From: Martyn White <Martyn.White@arun.gov.uk>
Sent: 15 November 2019 14:44
To: Planning.Responses <Planning.Responses@arun.gov.uk>
Cc: Anita Gardner <Anita.Gardner@arun.gov.uk>
Subject: M/32/19/PL

M/32/19/PL

The application is for 1 new dwelling with a detached garage within the Middleton-on-Sea estate. The estate has been identified as an Area of Character in the adopted Local Plan (2018), and as a consequence, is considered to be a non-designated heritage asset. these comments relate to revised plans which were submitted on the 8 October 2019.

**Elevation Materials
South**

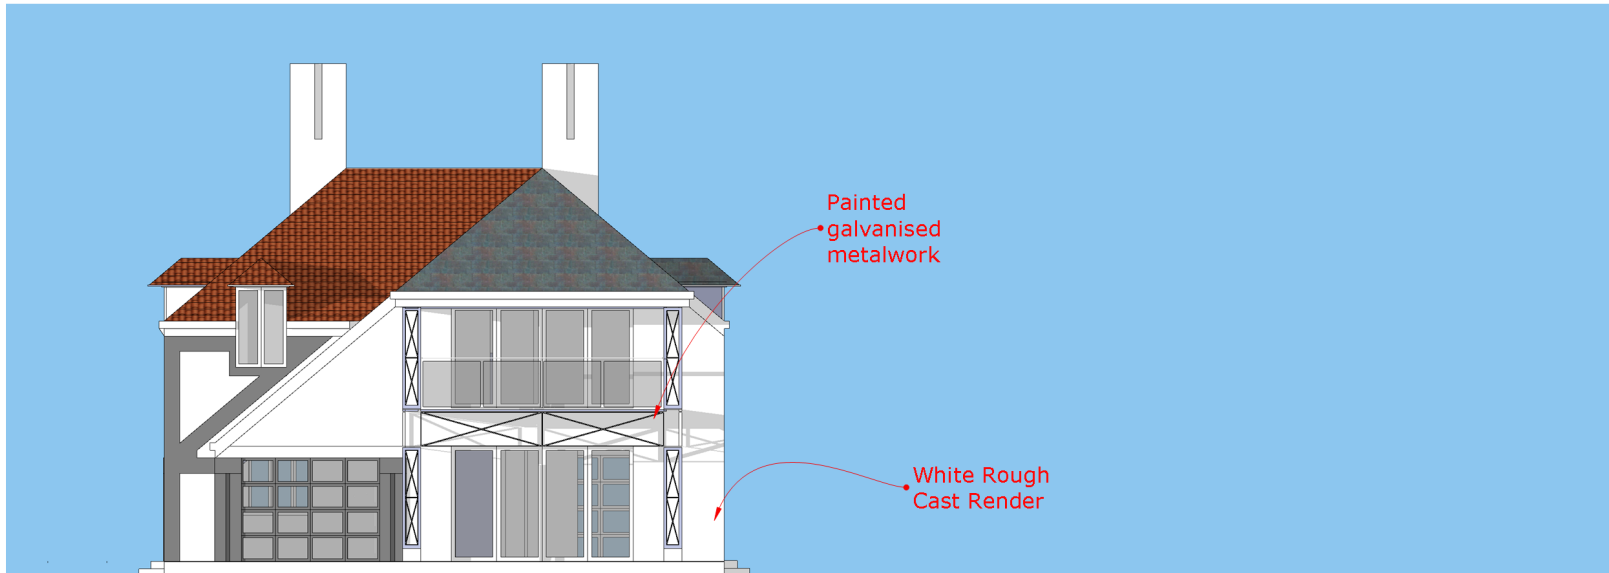
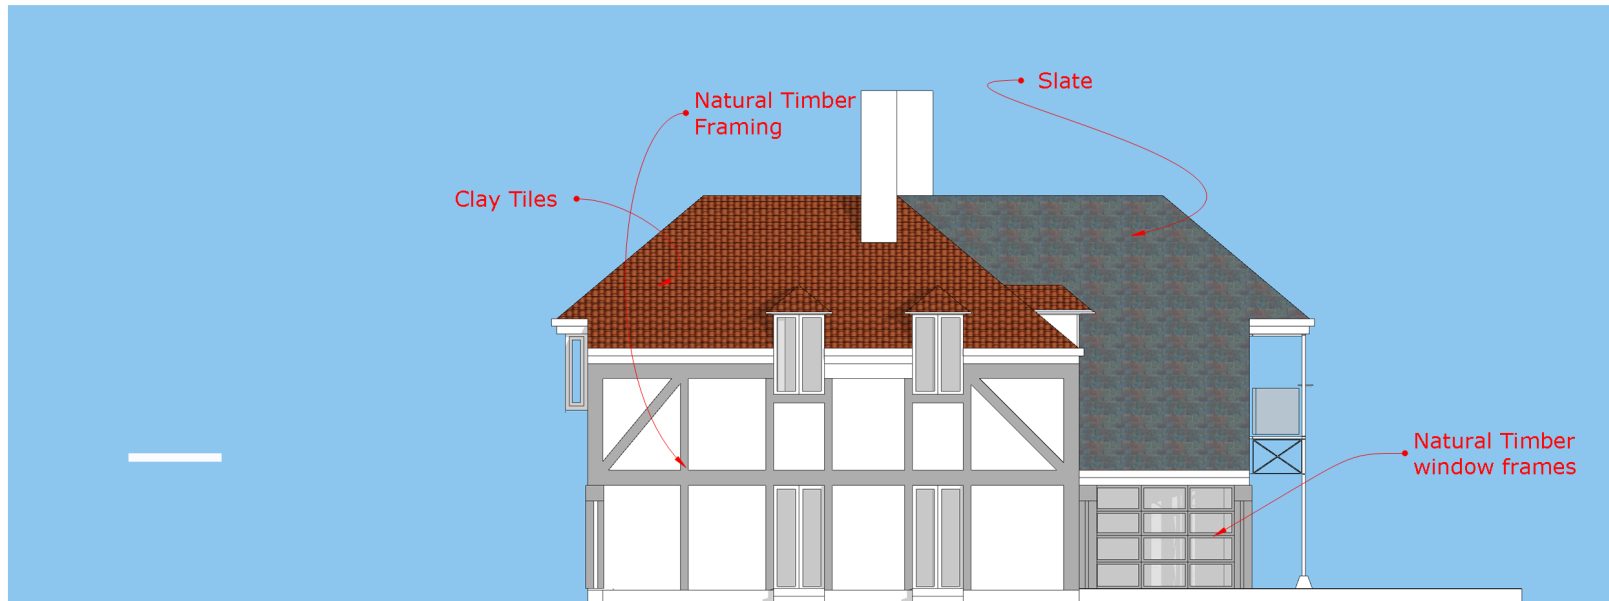
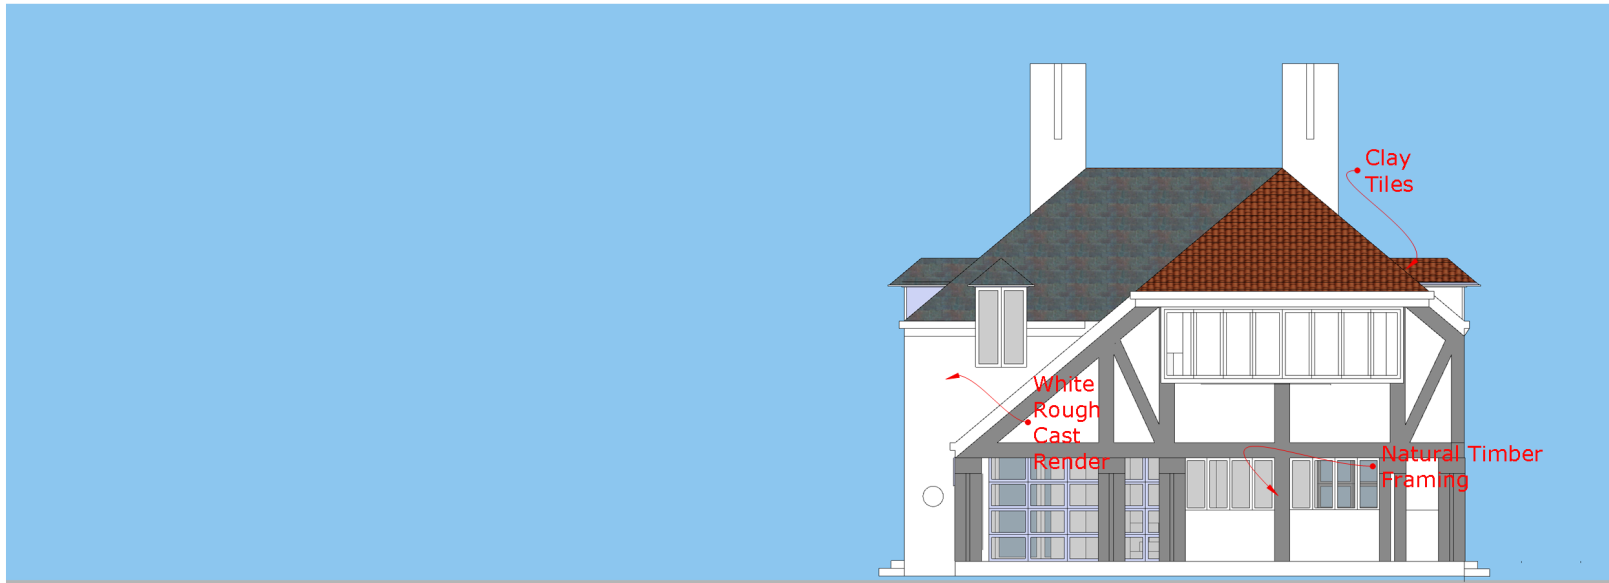
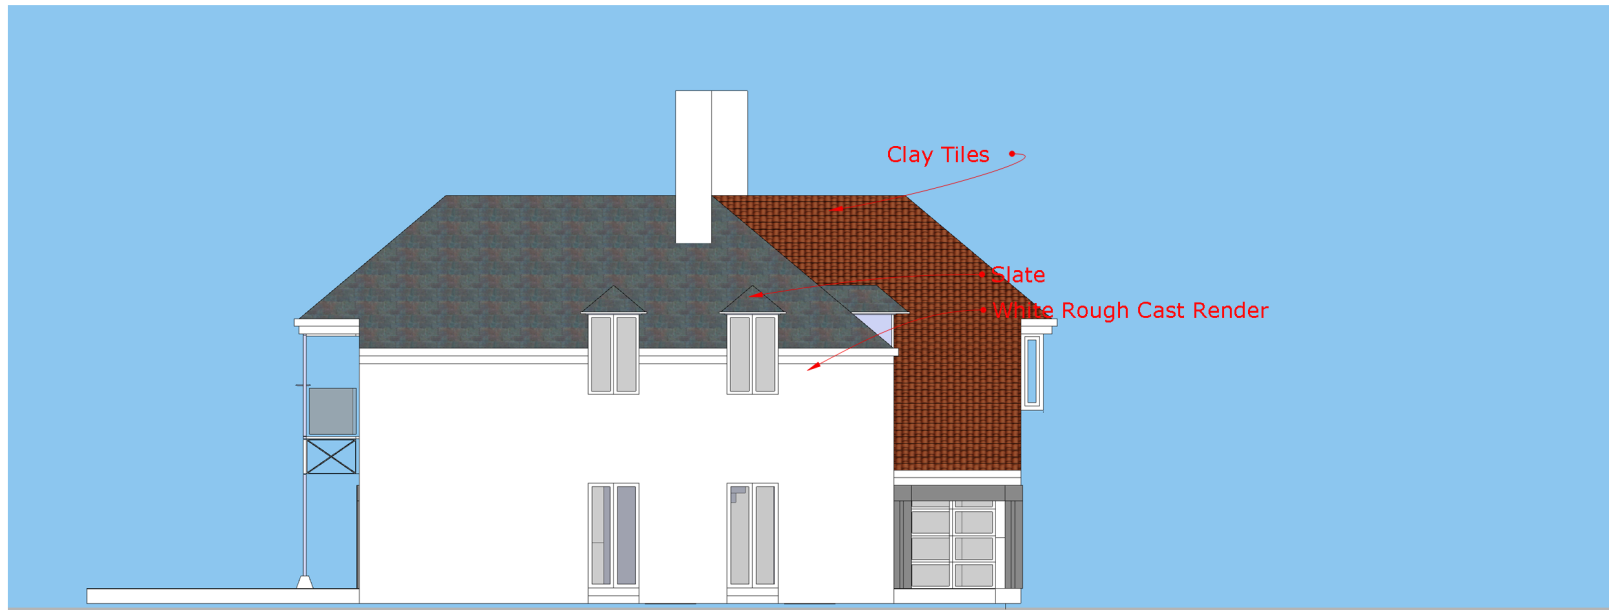
However, it is not clear what the stone walls are to be, and this should be clarified.

The success of the proposal will ultimately depend upon the quality of the materials and joinery used. It is suggested that they should be provided to the LPA by way of condition, should you be minded to approve the application.
